Ref: Planning Application M/153/18/PL – Land adjacent to 46 Sea Lane, Middleton on Sea

Proposed East Elevation in Context 1:200@ A3

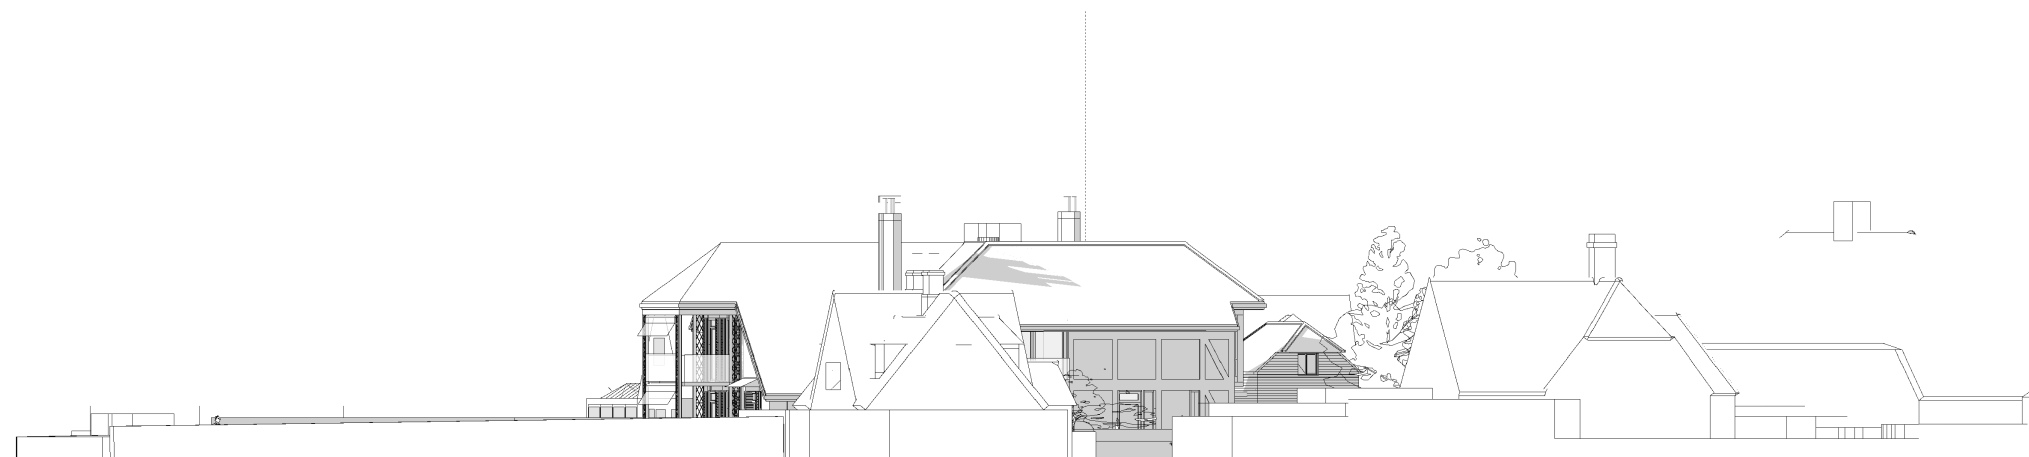
- a 50% increase (approx. 100 sq m) in additional floor space to that previously approved.
- a significant increase in the mass, height and scale of the dwelling bringing it far too close to the boundary with Sea Lane, projecting beyond the current building line, and dramatically changing the street scene at this point.

The result is a clear overdevelopment of this compact and sensitive site, which is contrary to the policies of the Arun Local Plan 2018 in that it fails to preserve and enhance our Area of "special" Character and has little regard for the Village Design Statement.
